Our Ref: LU/75/17/PL
Your Ref:

Town & Country Planning Act 1990 (as amended)
Town and Country Planning (Development Management Procedure) (England) Order 2015
Application for Planning Permission

Development Erection of 1 No. giant jumbrella with curved seating, 1 No. jumbrella, 1 No. pergola with associated seating & lighting & new window to South elevation.
Location The Windmill Harvester Coastguard Road Littlehampton

Existing Ground Floor Plan

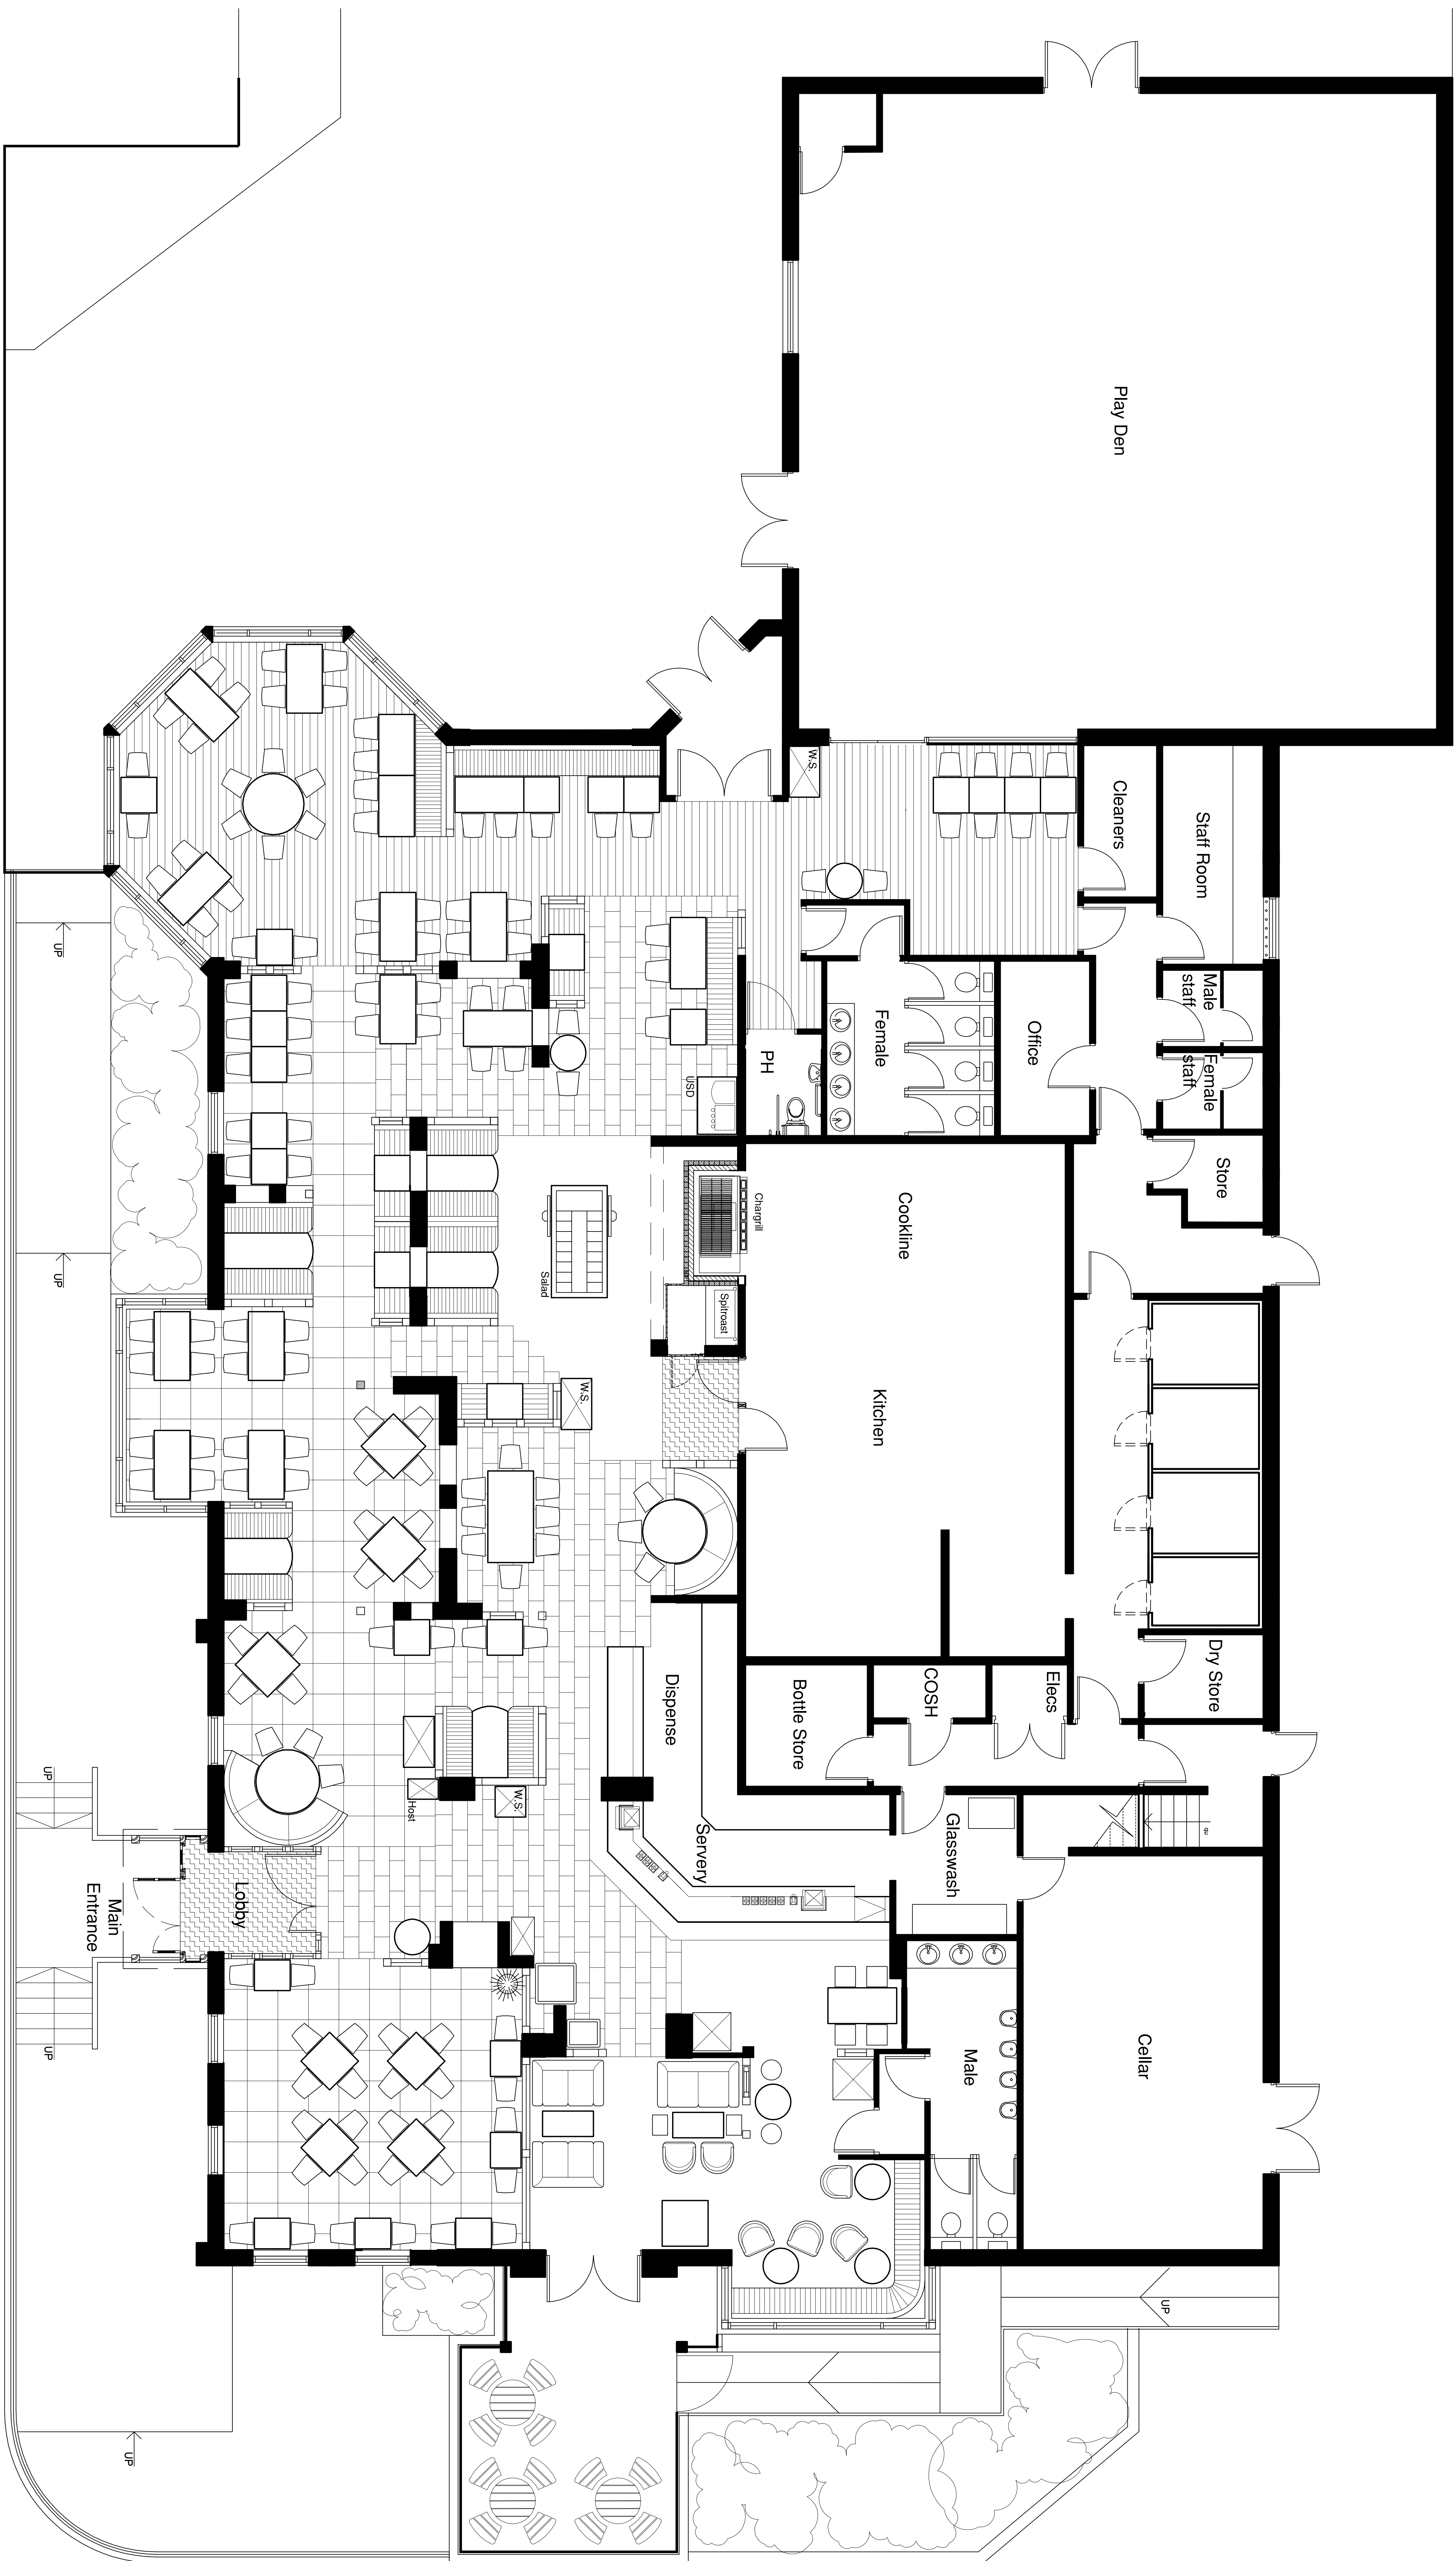
Please provide existing and proposed south floor plans to show the proposed window.
